3 October 2023

## **Hinckley National Rail Freight Interchange**

### **Response to Rule 17 Letter**

Figure 11211: Middle Super Output Areas

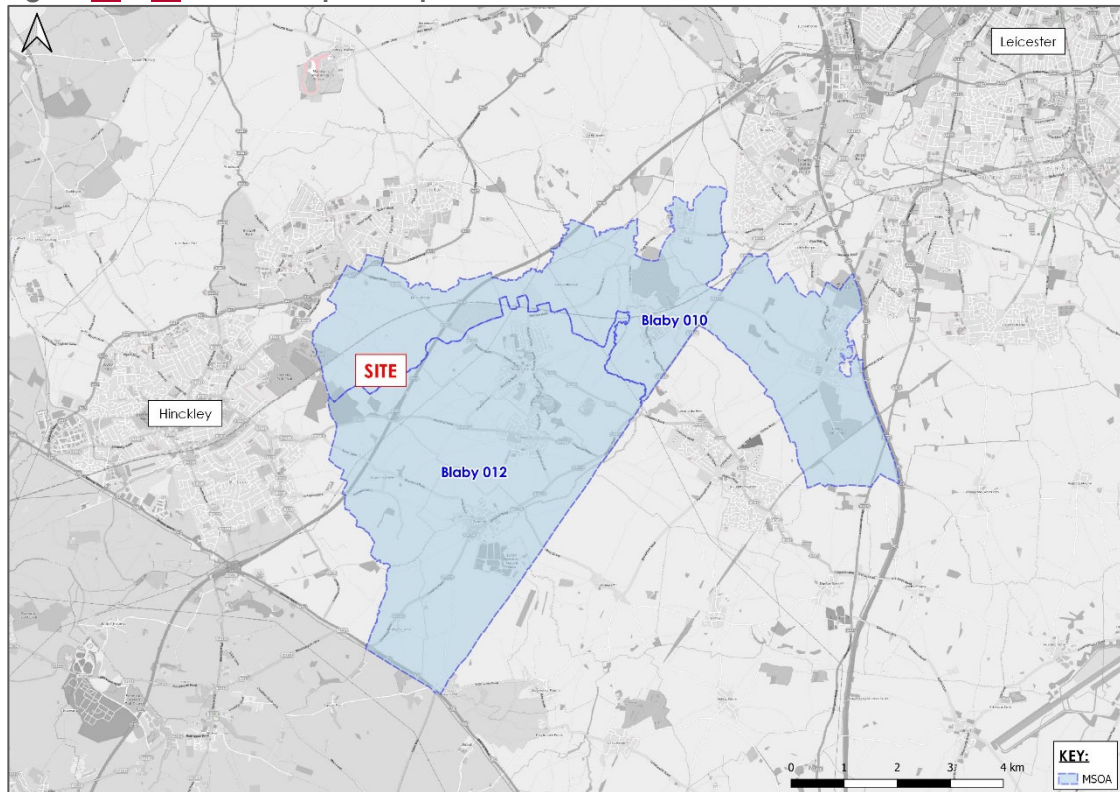
The ExA identifies that the “*modal split for traffic is based on that for the Middle Super Output Areas (the MSOA) (see Figure 6-2 of the TA [APP-138]) for the Application site. However, the locations of the Employee Trip Generation are different (see Figures 6-3 and 6-4) and may not have the same modal split*”.

The ExA has asked if the Applicant could further justify the use of the modal split for the application site rather than the modal split for where it is anticipated employees will live?

The Applicant has also been asked to “*undertake a sensitivity analysis of the effect of using modal split from where employees may live rather than that of the Application site. If this shows a material difference, then the Transport Assessment will need to be re-assessed based on using this modal split.*”

The Applicant does not consider that the ExA’s request requires further information because the TA was undertaken using a bespoke gravity model not influenced by the modal shift figures. Accordingly, the applicant does not consider that sensitivity testing requested by the ExA is necessary or appropriate. The Applicant explains its reasoning further below.

The HNRFI is located within the MSOAs shown in Figure 6-2 of the TA: document reference 6.2.8.1 Part 1 of 20, APP-138. The census data for anyone with a workplace in these areas has been used as a starting point to provide an initial indication of how many people travel to work in the area (i.e. including commuting from outside the area) by each mode.

The people trips and modal split referred to above has no direct correlation to the traffic generation and/or the distribution of vehicles assessed in the TA or the range of employee numbers. It is used here simply as a starting point in developing a sustainable transport strategy and to set initial targets for the Travel Plan. As the modal splits indicated here are not the basis of the TA there will be no need to re-assess the effects if a different modal split is assumed.
